**M25 JUNCTION 10/A3 WISLEY INTERCHANGE IMPROVEMENT SCHEME  
PROPOSED M25 JUNCTION 10/A3 WISLEY INTERCHANGE DEVELOPMENT  
CONSENT ORDER (“DCO”)**

**ROYAL HORTICULTURAL SOCIETY (“RHS”) – REGISTRATION NUMBER  
20022900**

**CAH REPRESENTATIONS**

Drawing Title: **LAND PLANS REGULATION 5(2)(i) SHEET 20 OF 31**

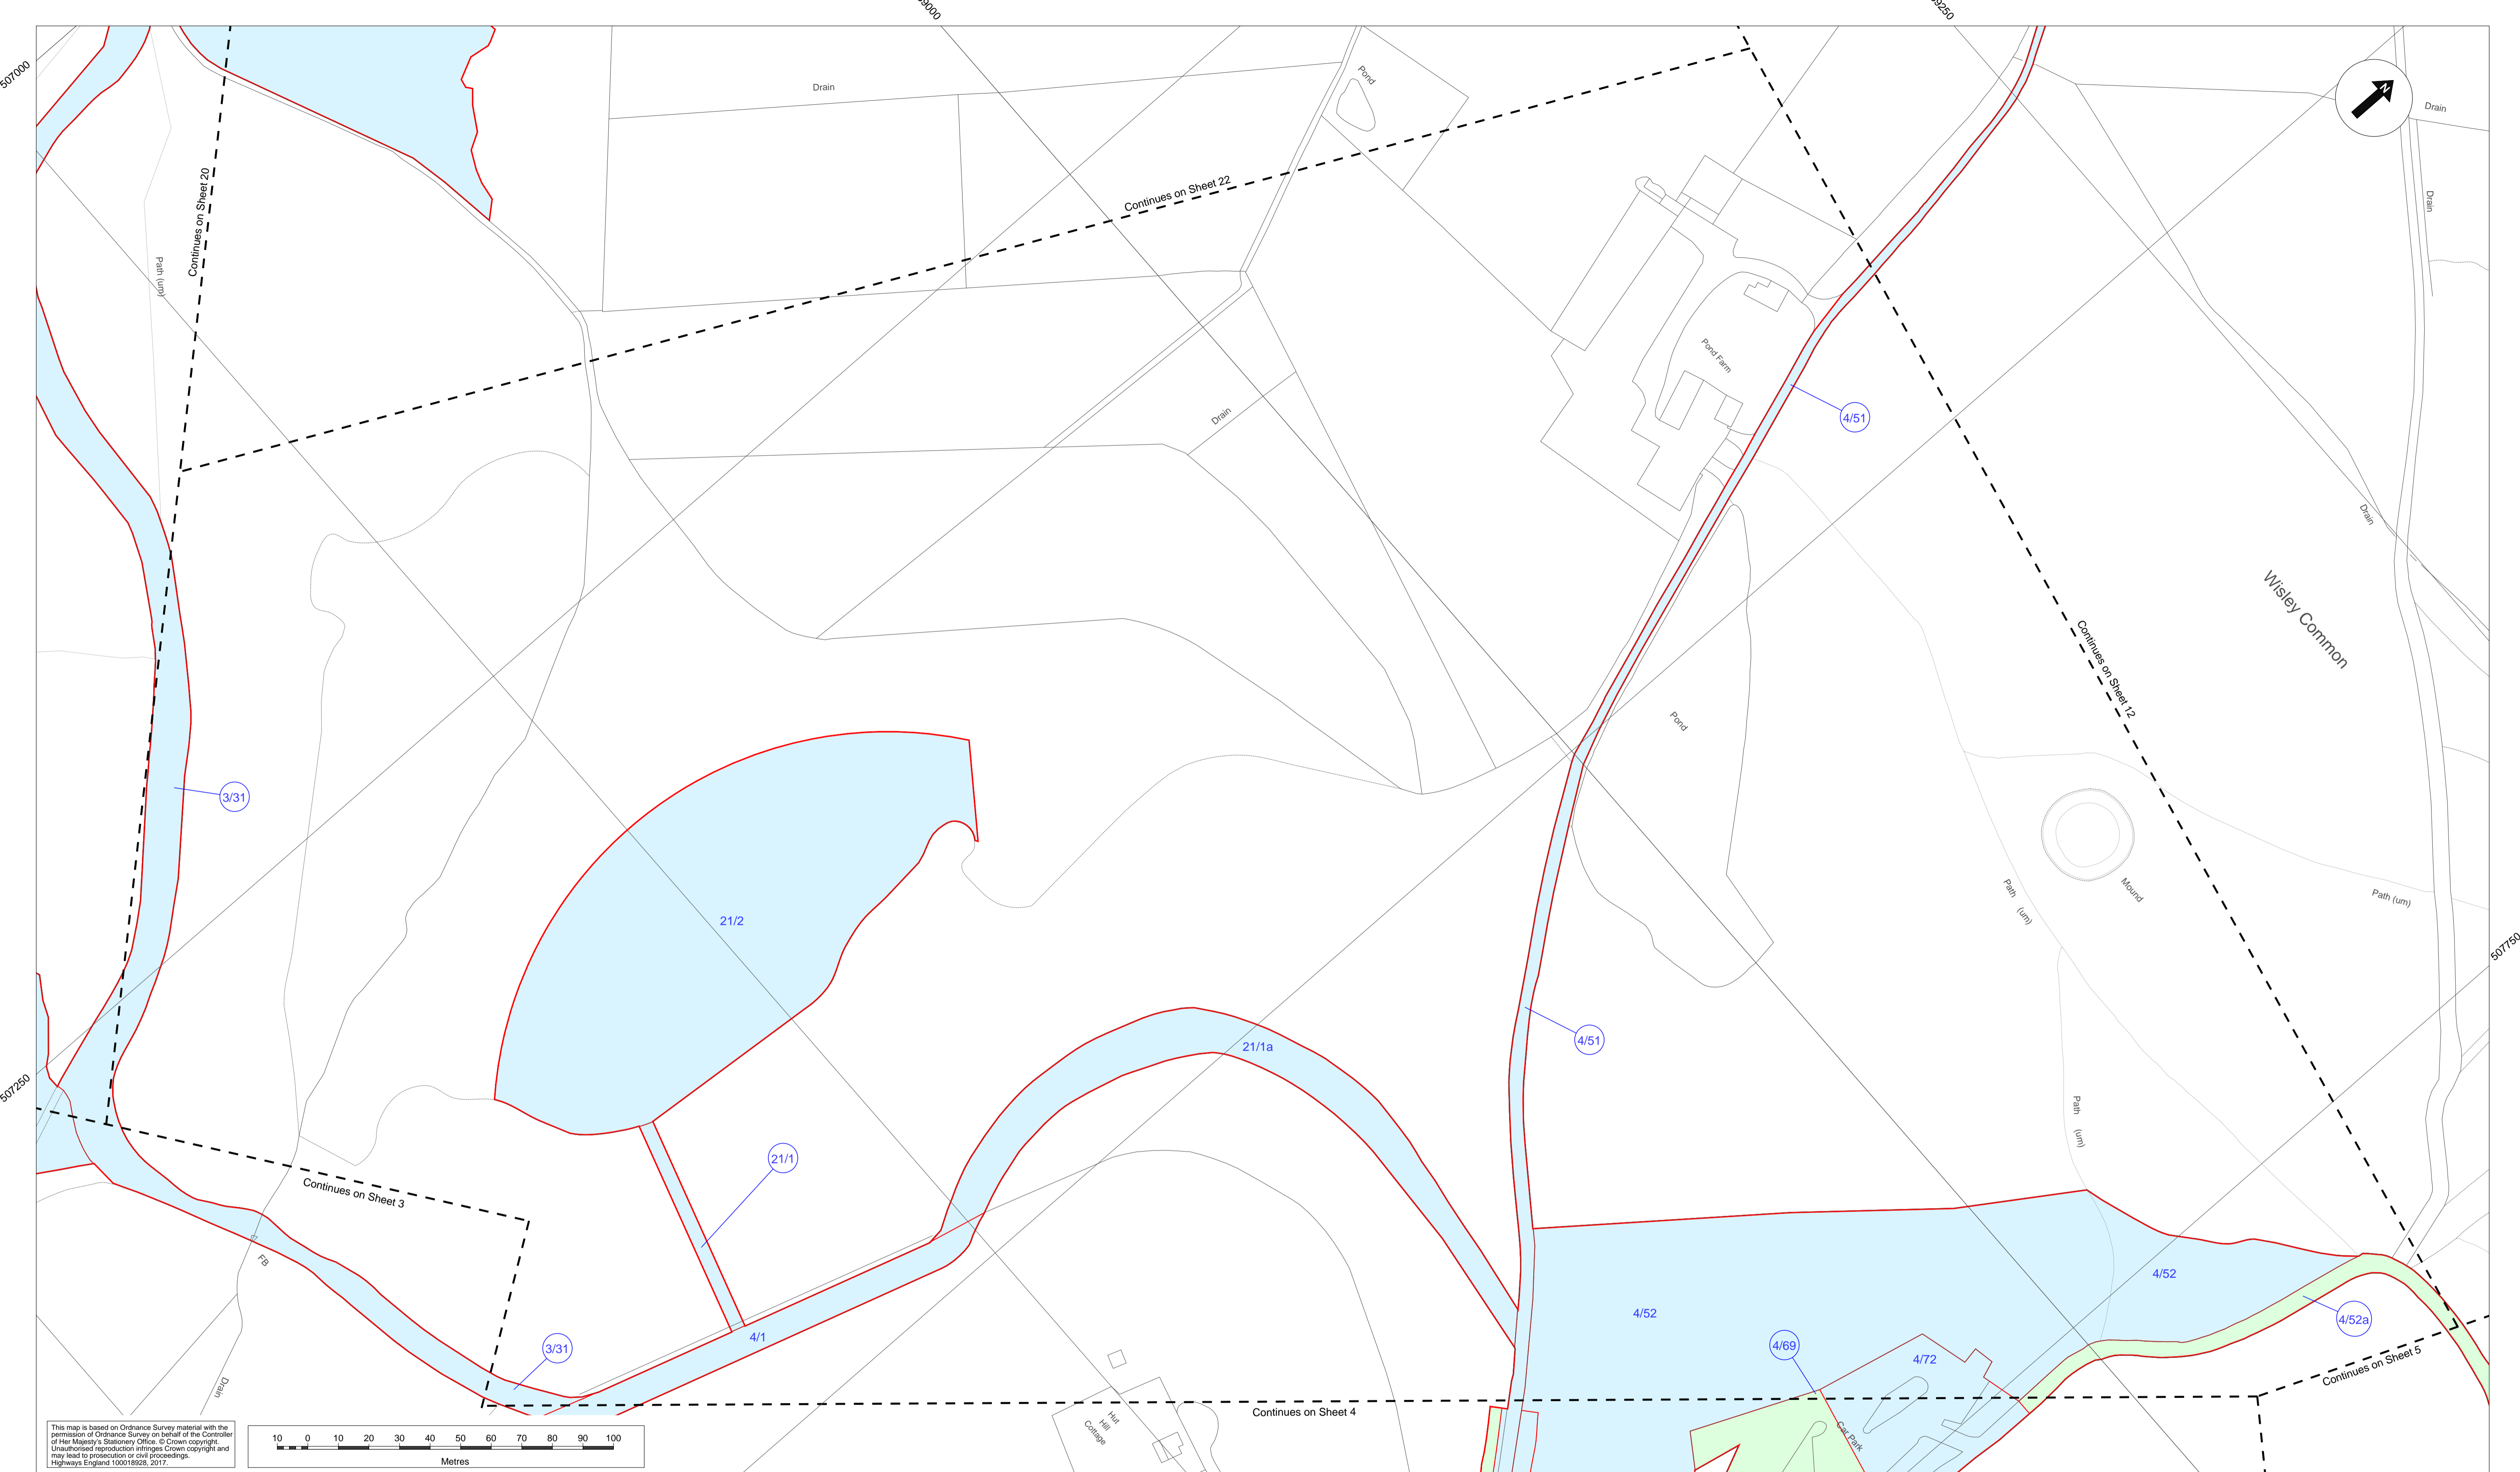
1. The RHS **OBJECTS** to the proposed compulsory acquisition of Plots 2/27, 2/27(a) and 2/30.
2. These Plots are shown on Land Plans Sheets 2 and 20 [**REP8-003**].
3. Attached as **Appendix 1** to these Representations is a copy of Plan M2002-A-003 Rev B prepared by the RHS based on HE concepts which shows the whole area of the plots to be taken together with an overlay of a possible version of the proposed Overbridge that is to be constructed on them.

4. Plot 2/27 (which is to be acquired permanently), together with Plots 2/27a and 2/30 (which will be subject to temporary possession), lie at the main vehicular entrance to the RHS Gardens at Wisley from the A3. Plot 2/30 comprises part of Wisley Lane, the access road into, and out of, the RHS Gardens at Wisley. The plots that are to be acquired are in

6. The purpose of acquiring Plot 2/27 is to construct the western end of a bridge that will pass over the A3 and provide a new entrance to the Gardens via a rerouted Wisley Lane. HE says that access to the Gardens from Wisley Lane will be maintained throughout the scheme works and during the 12-18 month construction period of the Overbridge. The RHS doubts this claim especially as the details of HE's proposals for the Overbridge and its construction method are still to be confirmed.

10. The Overbridge will require the compulsory acquisition and temporary possession of a part of the Grade II\* Registered Park and Garden footprint as designated by Historic England. The impact on the heritage assets of this physical landtake, its trees, and the cultural and experiential change for its users, has not, in the Society's opinion, been justified.

15. It is important to note that the alignment of the Overbridge is “skewed” so that the Wisley Lane “left-out” could be retained. Whilst the RHS would welcome the retention of the “left out”, the unfortunate consequence of this is that landtake outside the RHS front door is increased rather than if the Overbridge had been designed as running perpendicular to the A3.
